Environmental Health Division
1675 W. Garden of the Gods Road
Suite 2044
Colorado Springs, CO 80907
(719) 578-3199 *phone*
(719) 578-3188 *fax*
www.elpasocountyhealth.org

Mose Minor Subdivision, MS-20-5

Jeanette Mose Subdivision

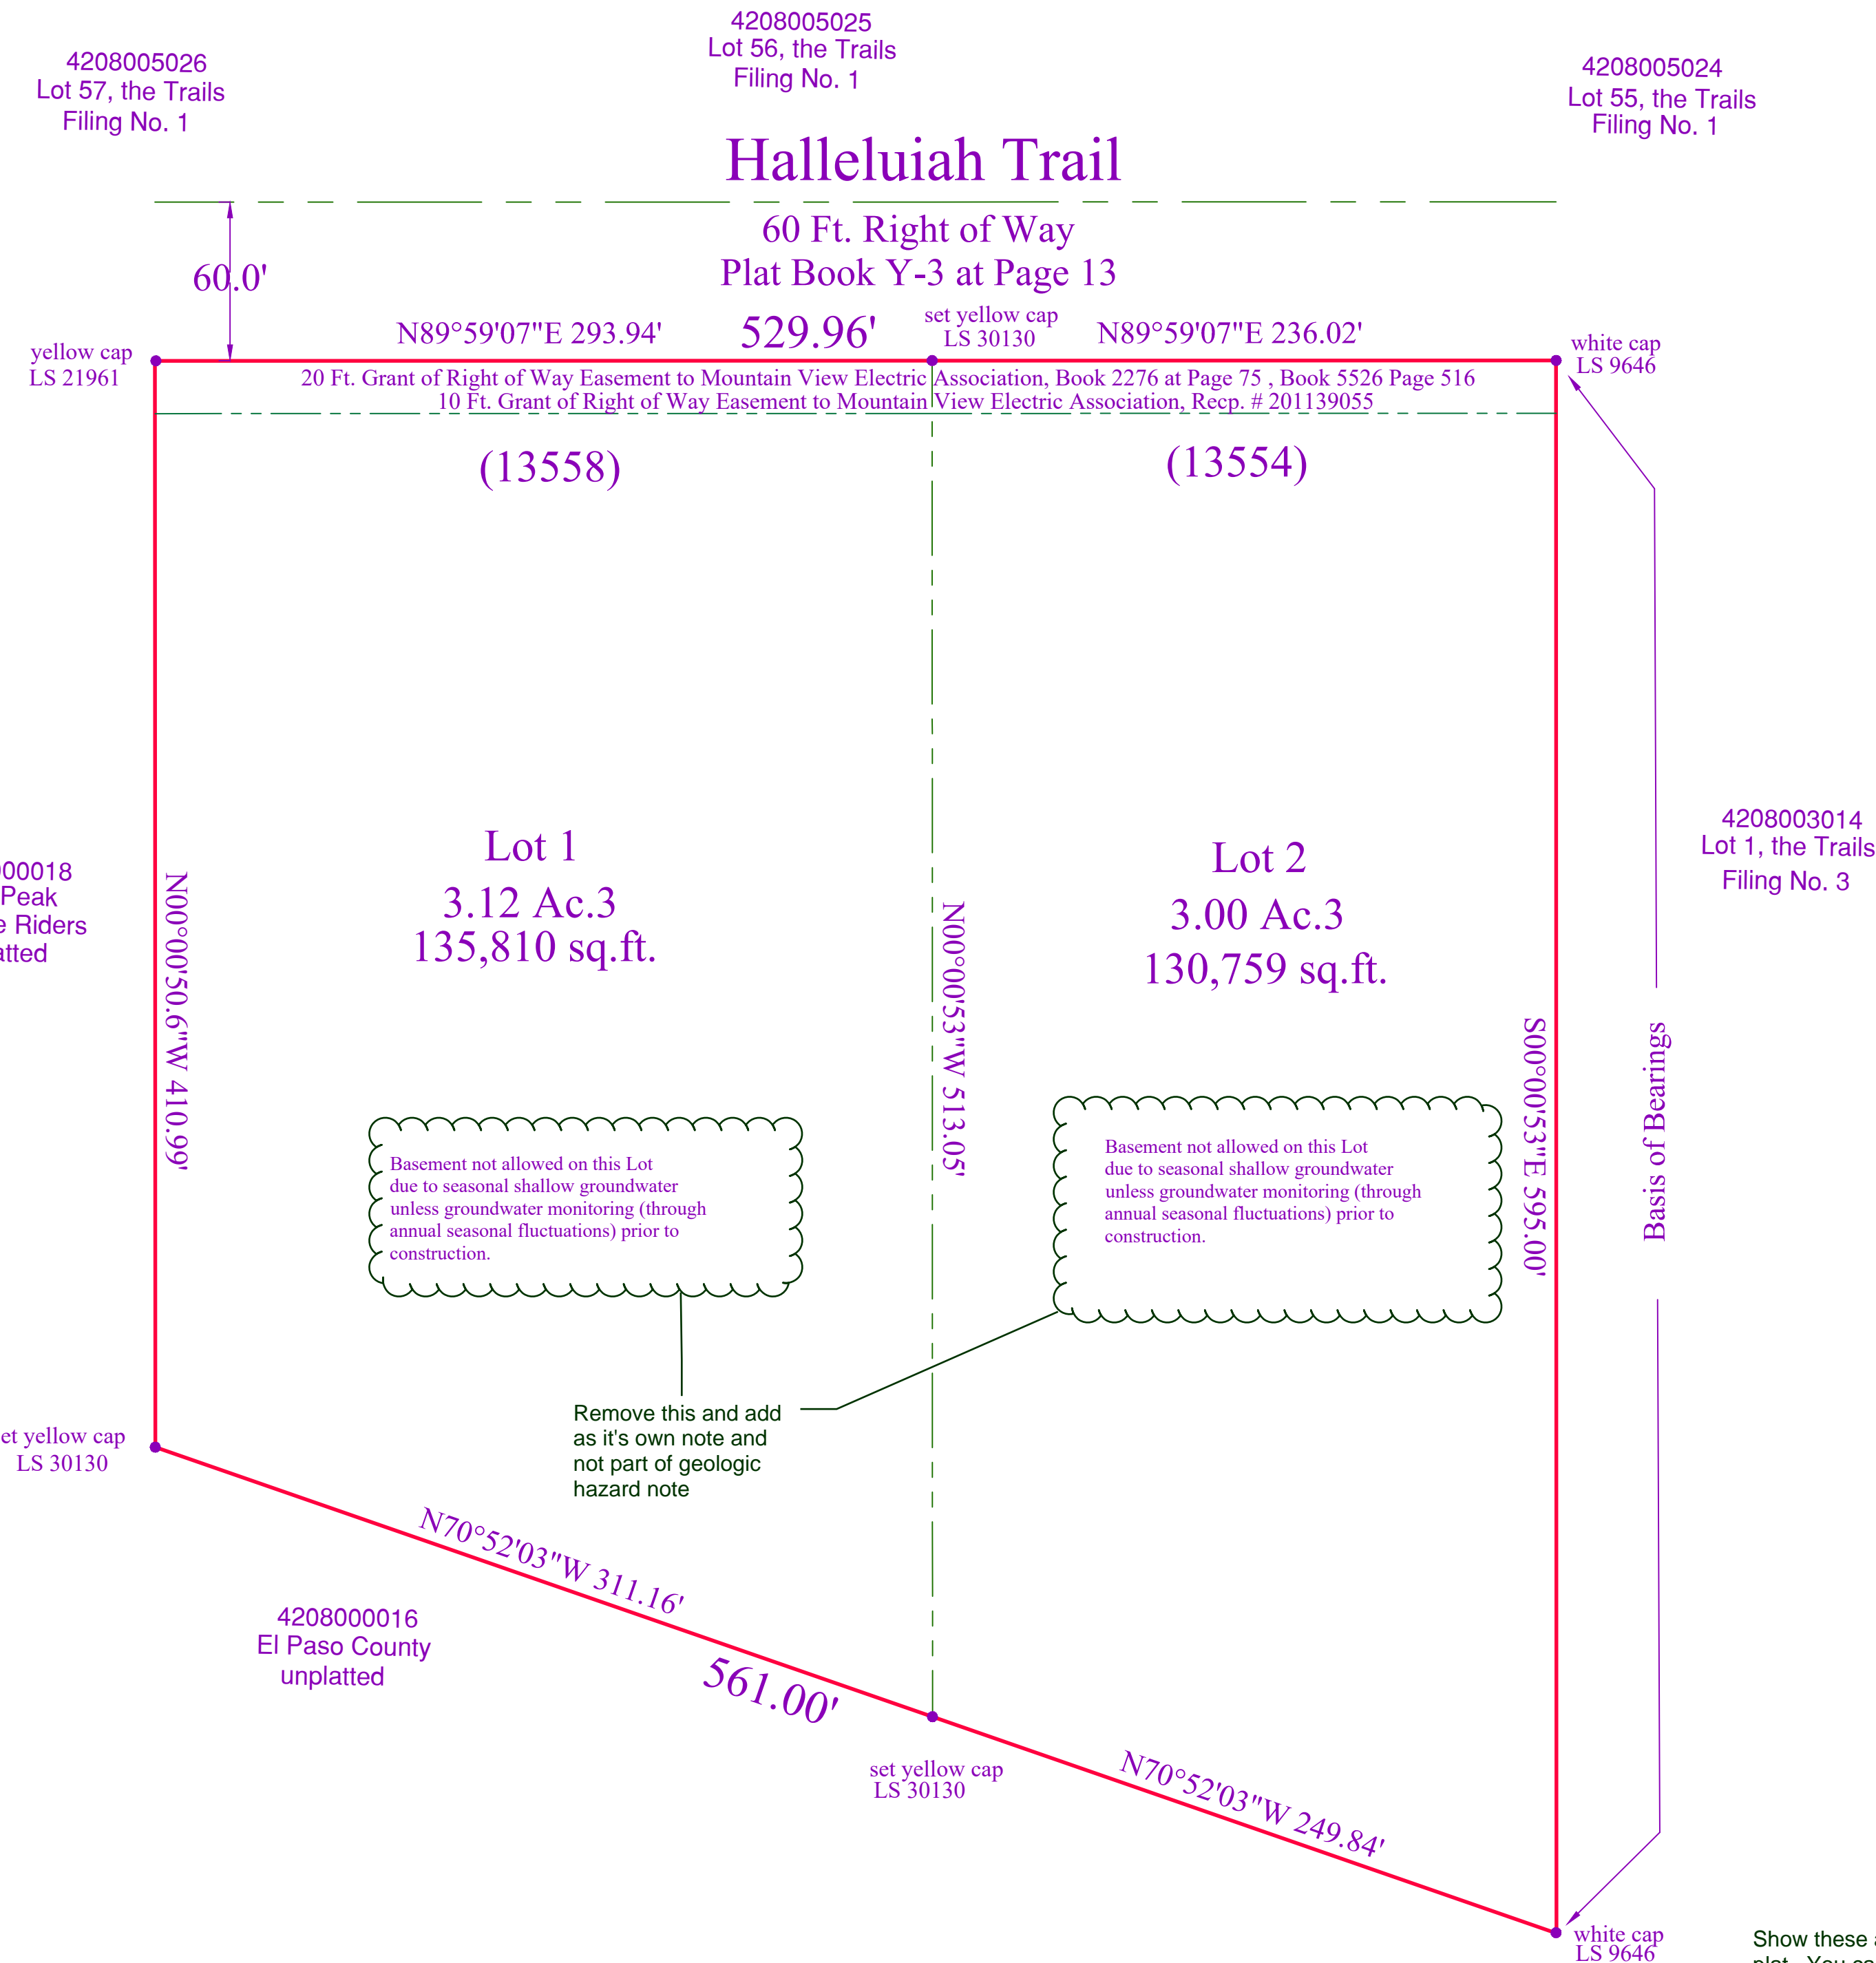
This information seems to conflict plat note #12. The OWTS Report must show proposed septic drain field locations for each lot. Report as submitted still only addresses lot 1.
